From: Sarah Featherstone [REDACTED]
Sent: 27 September 2019 10:12
To: Anita Gardner <Anita.Gardner@arun.gov.uk>
Cc: Martyn White <Martyn.White@arun.gov.uk>
Subject: Mill Cottage applications CM/38/19/PL and CM/39/19/L

We have read through Martyn White's (Conservation officer) comments on Mill Cottage applications CM/38/19/PL and CM/39/19/L which are very useful and encouraging and we would like to confirm and respond as follows:

Mill Cottage:

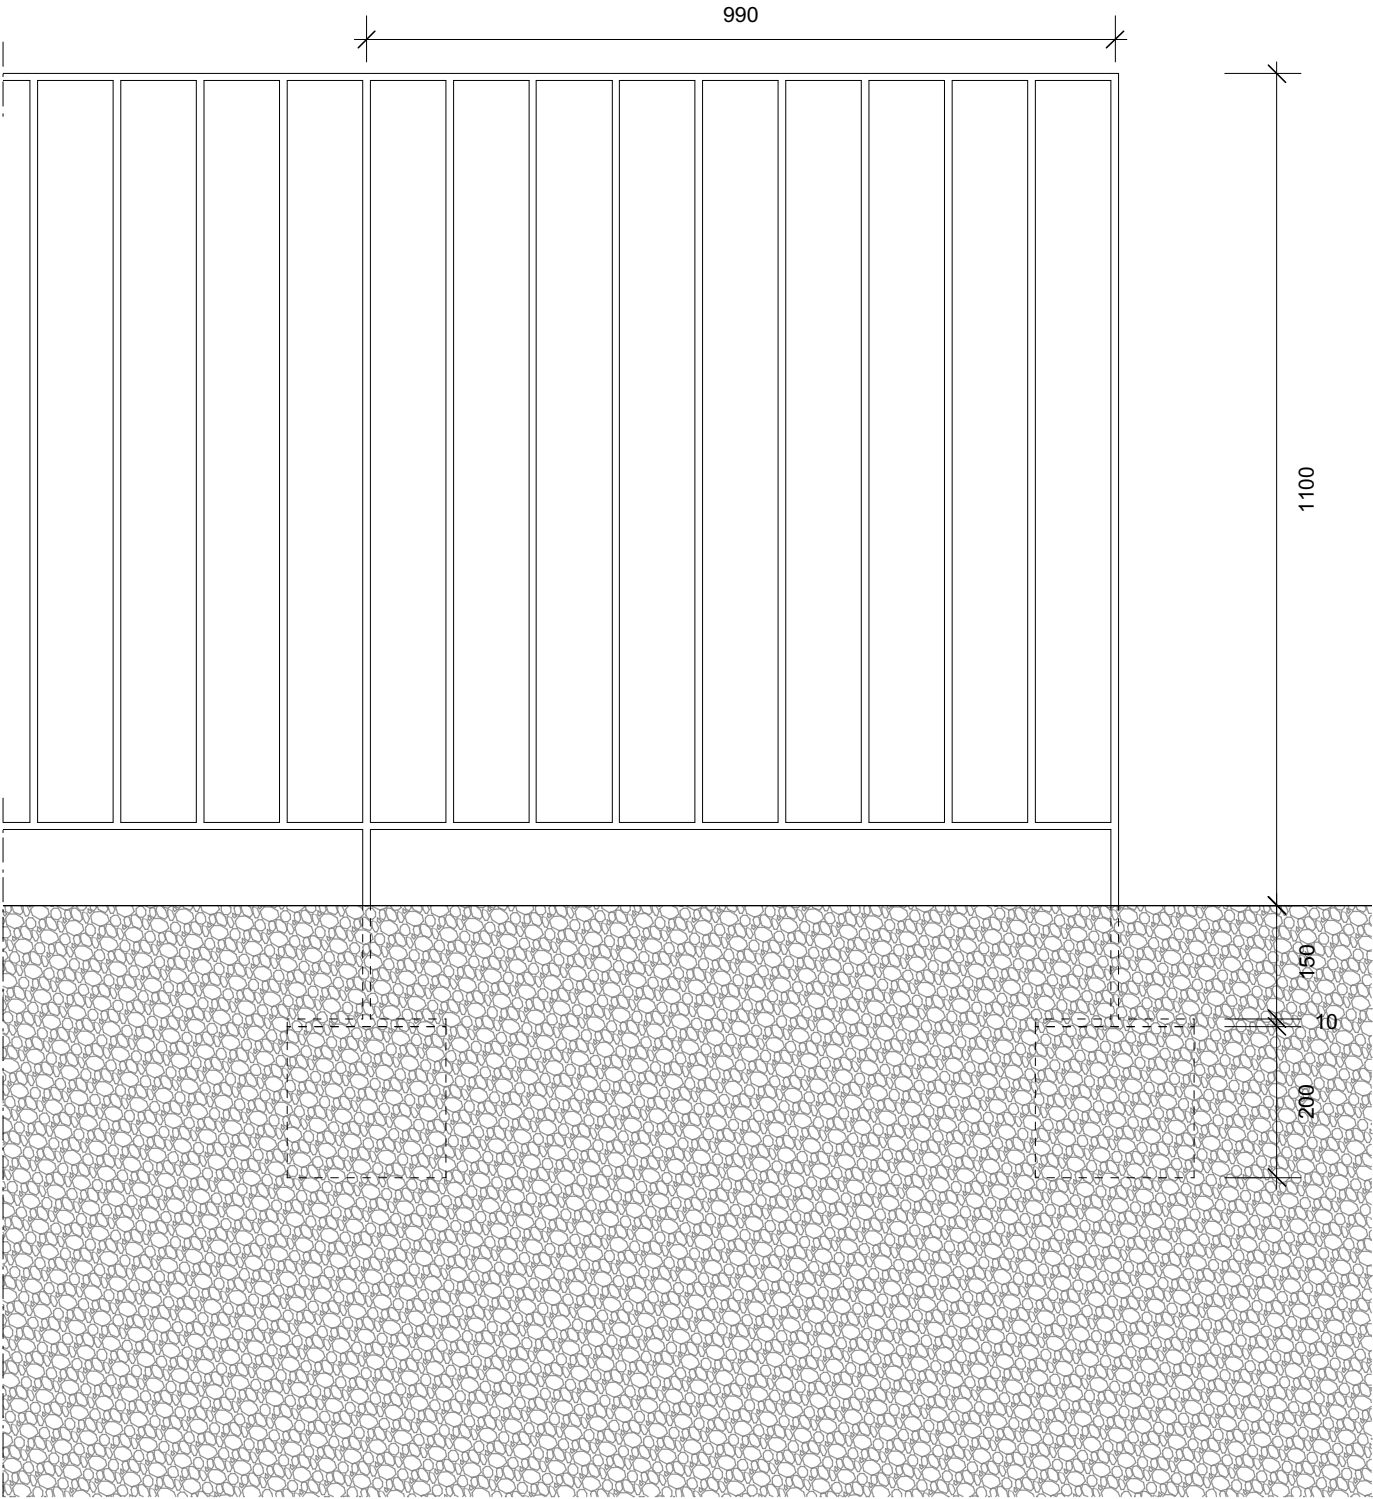
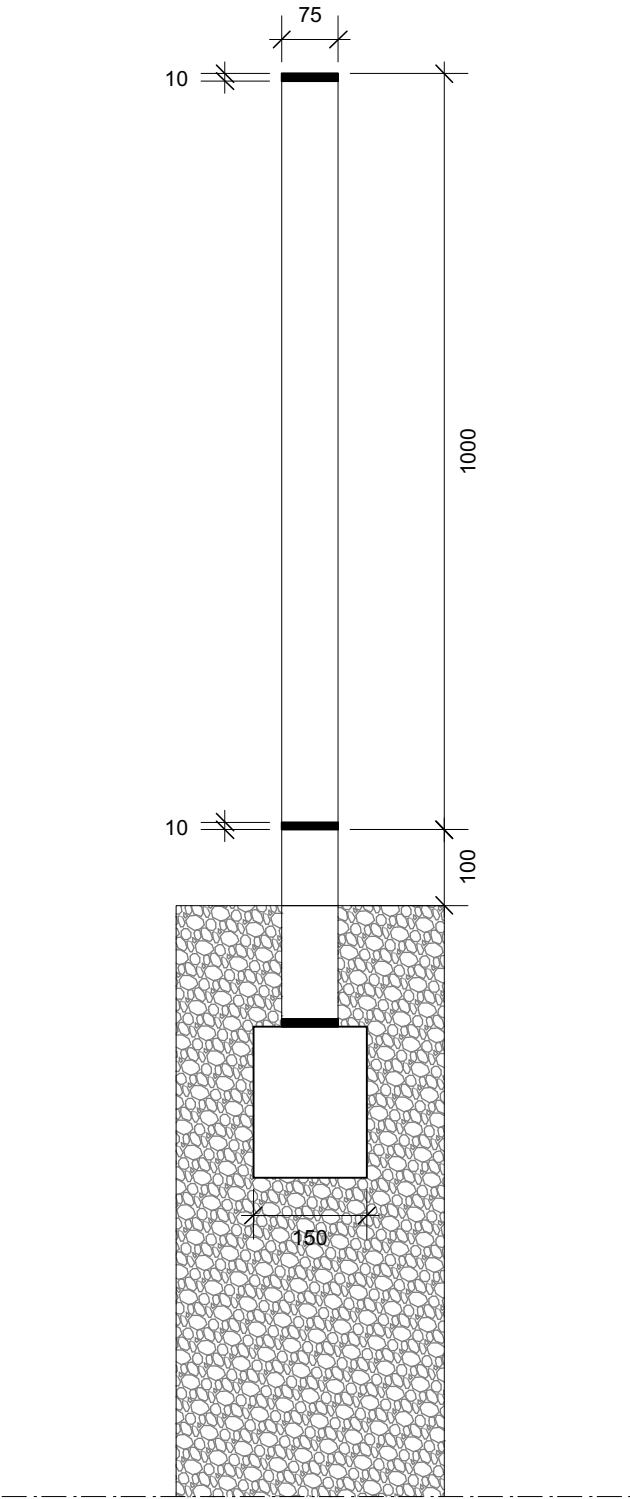
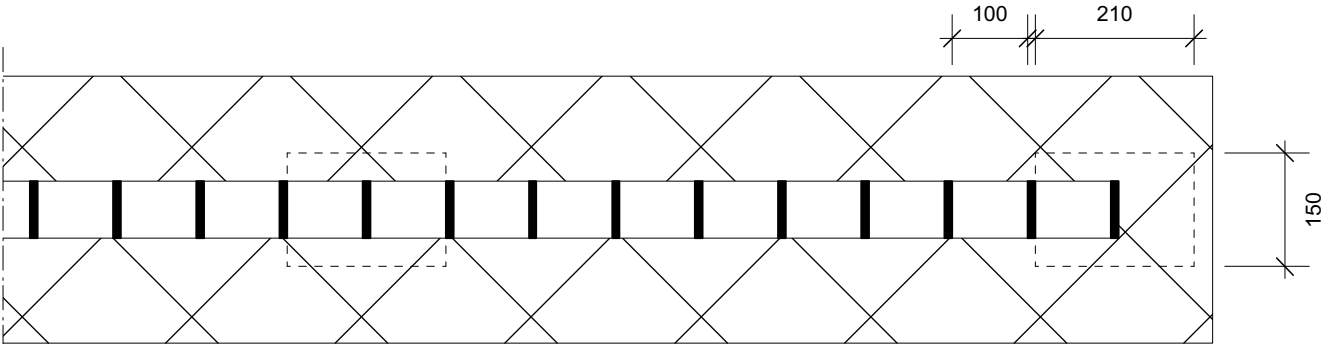
- Internal flooring - we confirm the floors are replacement concrete slab with polished concrete screed finish.
- We can confirm the balustrade will be painted not sprayed.
-
- **2. Additional details which we can issue next week:**
- Shutters detail to windows in flint walls
- Detail of stone paving specification on external terrace
-
- **3. Samples:**
- We can provide a sample panel of new walling to front terrace - can this be a condition prior to commencement of this part of work only?
